Project Name: **Baxter Boulevard and Back Cove Trail Improvements and Structures associated with City of Portland CSO Project**
Project ID: 2012-587
Address: North Baxter Boulevard and southeast corner Payson Park
CBL: 159-G-1
Applicant: City of Portland Department of Public Services
Planner: Jean Fraser

TO: Jean Fraser, Planner
FROM: David Senus, P.E. & Ashley Auger, E.I.T.
DATE: November 7, 2012
RE: Level I Site Plan Application – Baxter Blvd Storage Conduit Utility Building and Trail Work

TO: Jean Fraser, Planner
FROM: David Senus, P.E. & Ashley Auger, E.I.T.
DATE: September 25, 2012
RE: Level I Site Plan Application – Baxter Blvd Storage Conduit Utility Building and Trail Work

Drawing file: Original Submissions / 09006 SHEET 11 90% 082412.PDF

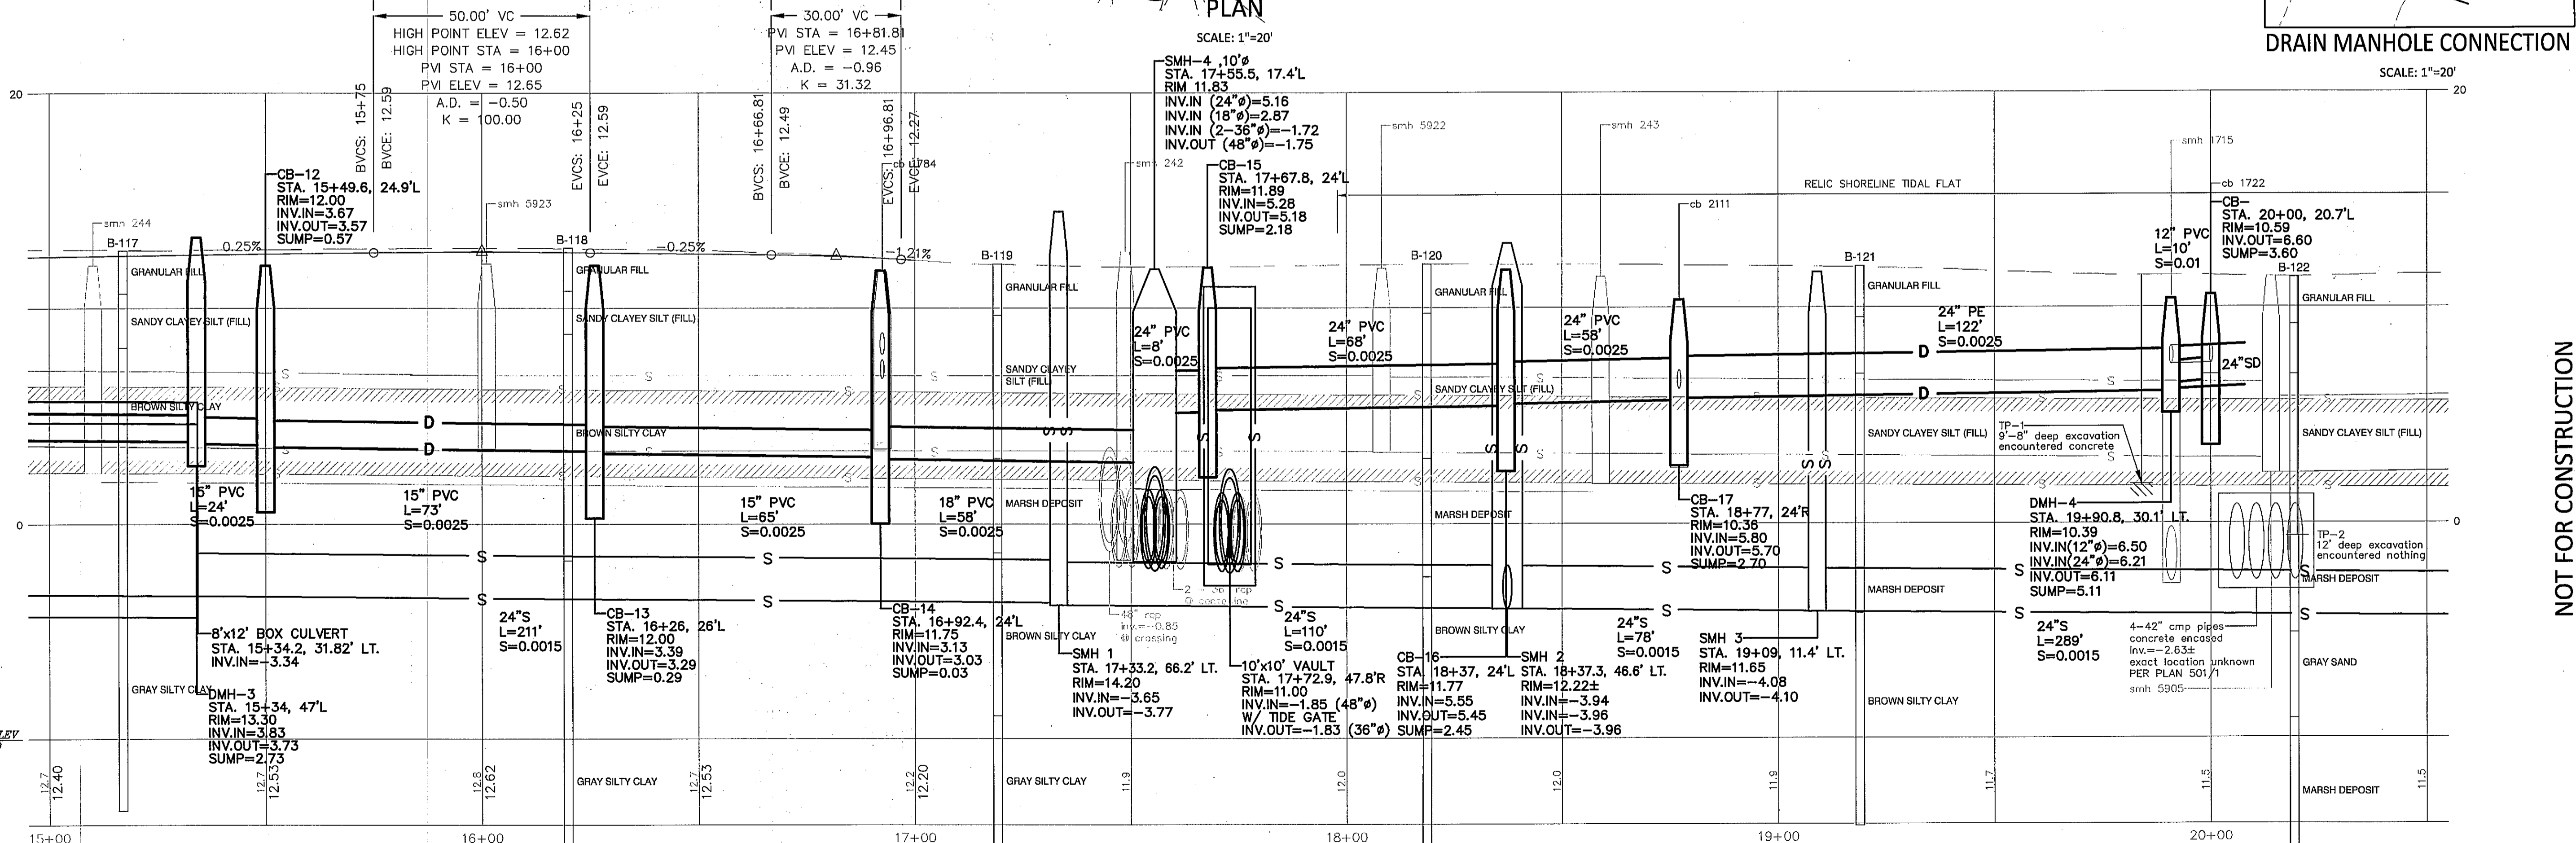
- 1) The Applicant should provide additional information on the installation and/or replacement of slope stabilization riprap, including stone size, and thickness.
